Re: **SSI-9487; Narromine to Narrabri (N2N) Inland Rail Project; PIR Submission**

21 September 2022

APPENDIX A: Issues identified in the PIR

Figure B11.1 Road network (map 1)

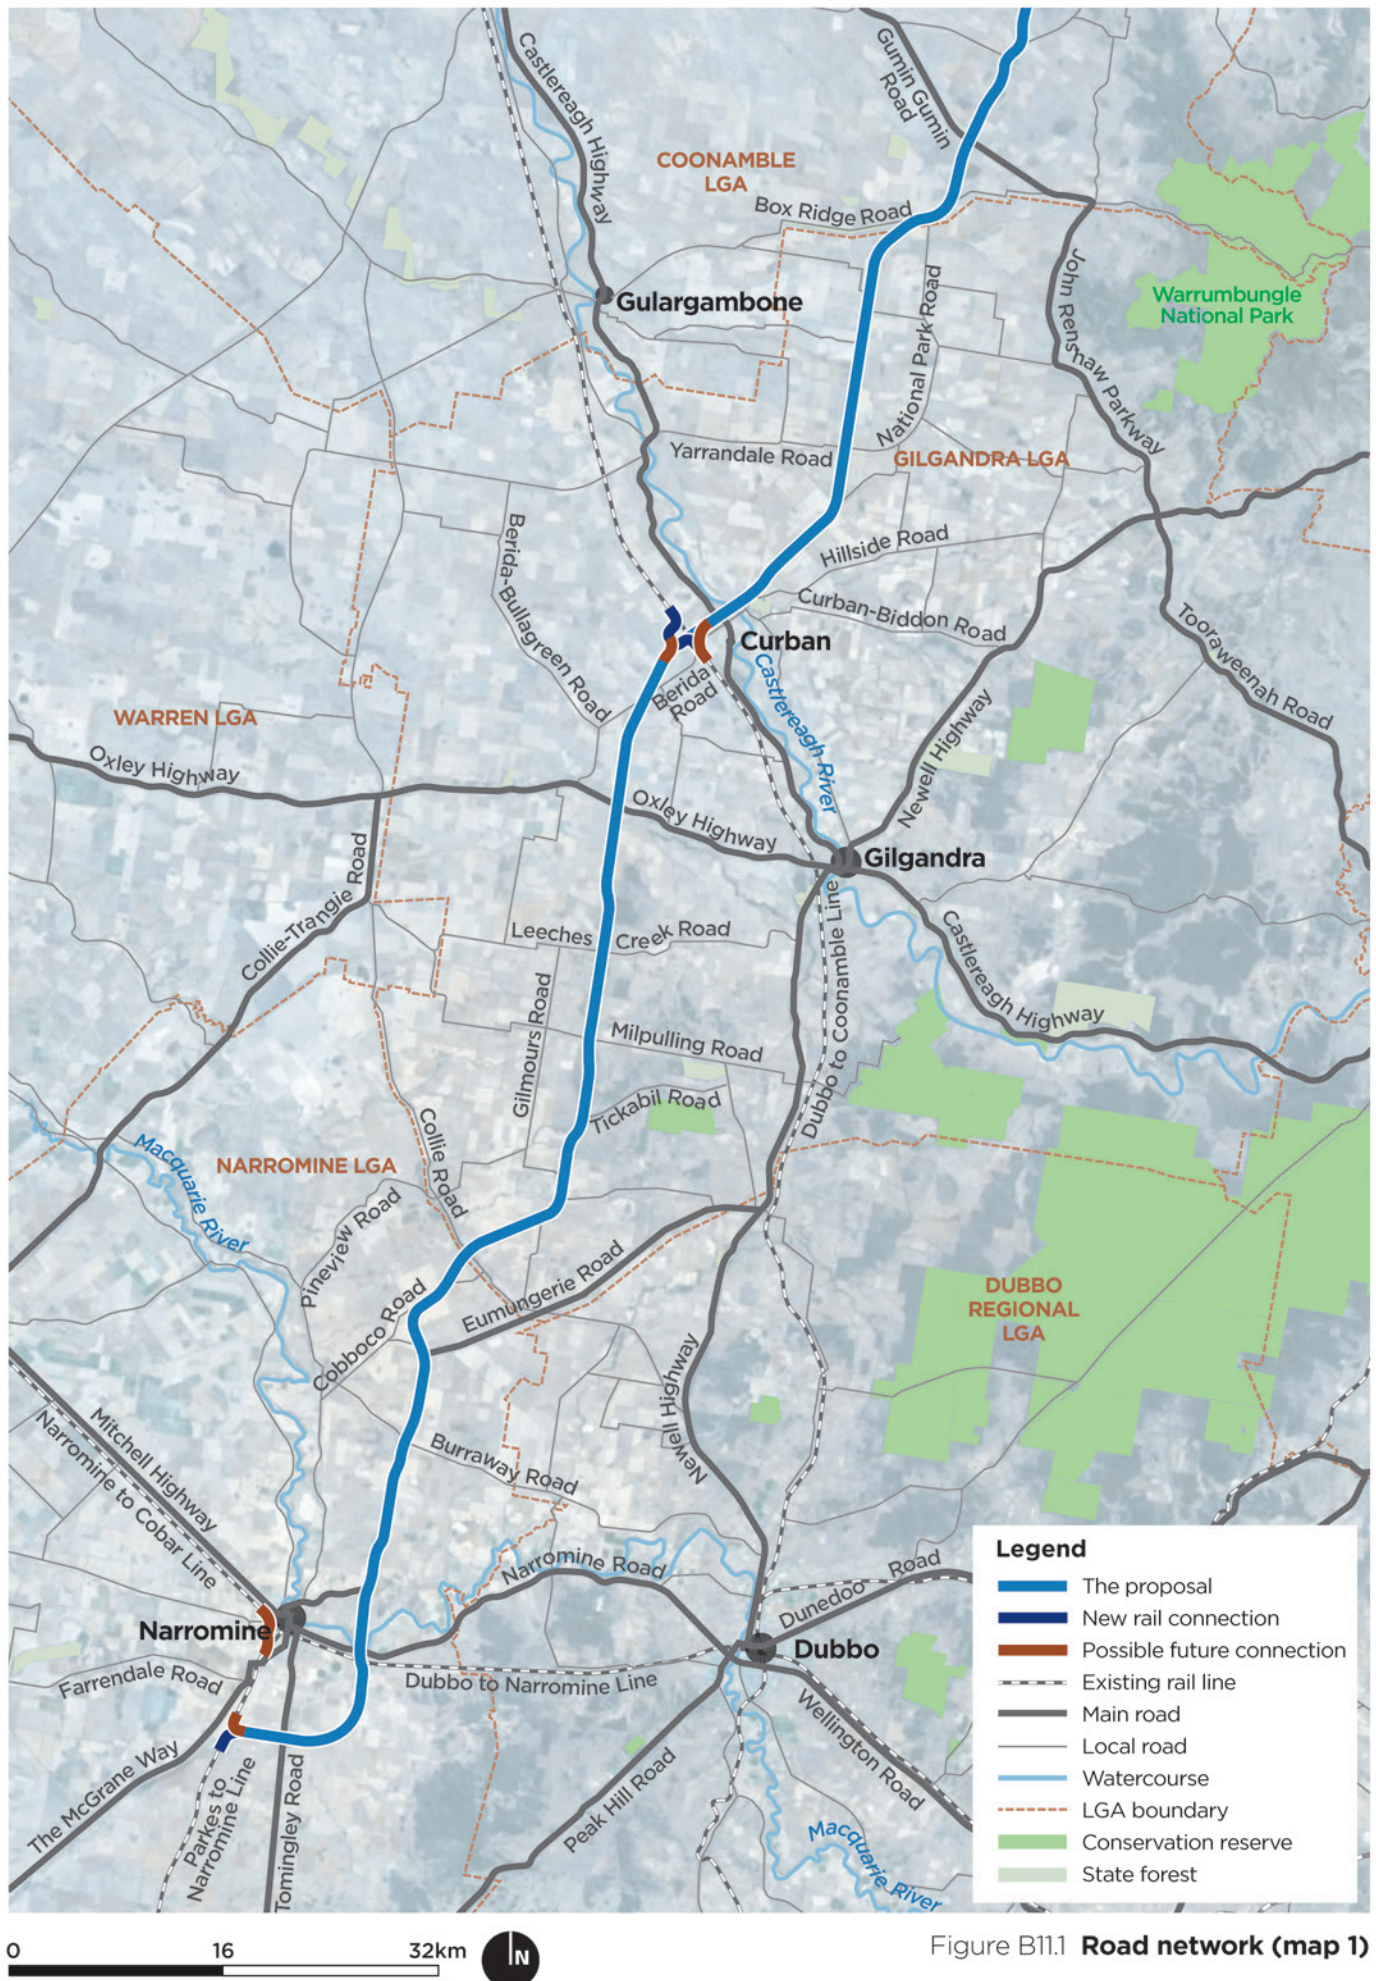
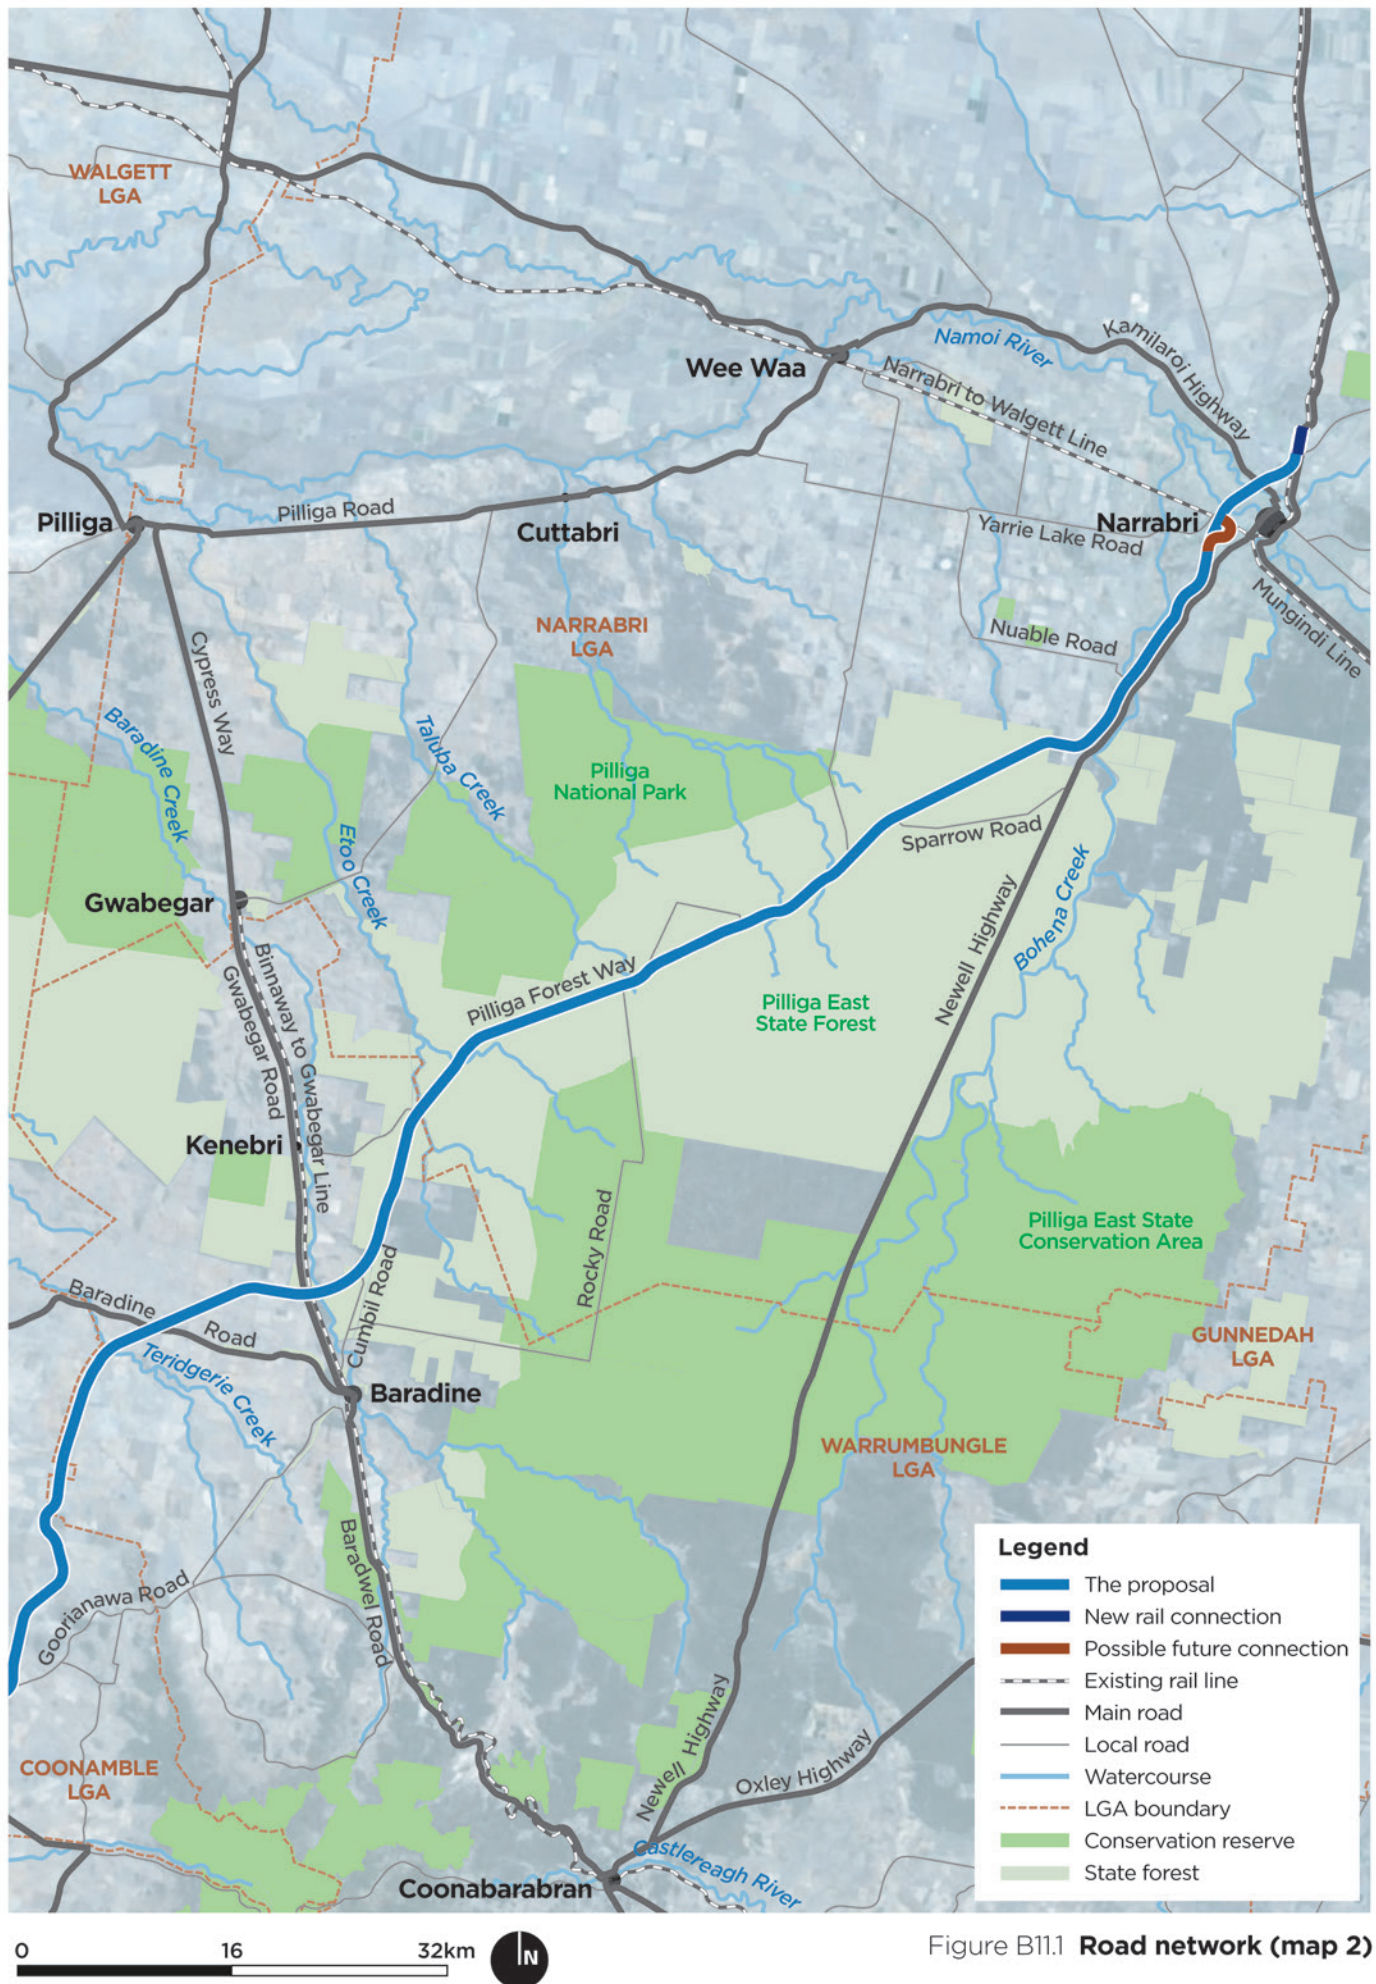
Transport has reviewed the submitted documentation and notes the proposal still includes at grade crossings of classified roads. Transport, in its previous submissions, has clearly stated that all new Inland Rail interfaces with classified roads are to be grade separated. As such, Transport objects to the proposal, as submitted. Transport is willing to reconsider its objection, subject to amended information being provided for review that provides for grade separated interfaces of classified roads and Inland Rail.

Chapter	Topic	Issue	Transport Position and Submission Request
<ul style="list-style-type: none"> Main Report/4.6.3 	Level Crossings	<ul style="list-style-type: none"> Level crossings are proposed at interfaces with six State roads. There are significant safety risks associated with level crossings, particularly where new interfaces will be created as road users are unaccustomed to level crossings on this route. 	<ul style="list-style-type: none"> Transport has consistently stated its position that all interfaces with State roads be grade separated to provide the maximum safety to road users and eliminate delays created by level crossings. TfNSW requires the proponent to include the Safe System Framework into considerations of level crossing safety.
<ul style="list-style-type: none"> Main Report/2.11 	Construction	<ul style="list-style-type: none"> The proponent proposes the use of Gibbons St/Newell Hwy intersection in Narrabri as the main construction access point for the construction of the Namoi flood plain bridge. The intersection has inadequate storage and deceleration auxiliary lane lengths (both North and South bound) to cater for the extra HV movements generated by the proposal. As the proposed haul route goes through a residential area and past 2 aged car facilities, the hospital, and a childcare facility a higher risk is introduced. 	<ul style="list-style-type: none"> The PIR does not mention the proposed use of Gibbons St/Newell Highway intersection in Narrabri. The proponent is required to provide a risk assessment and justification for use of this route during construction.
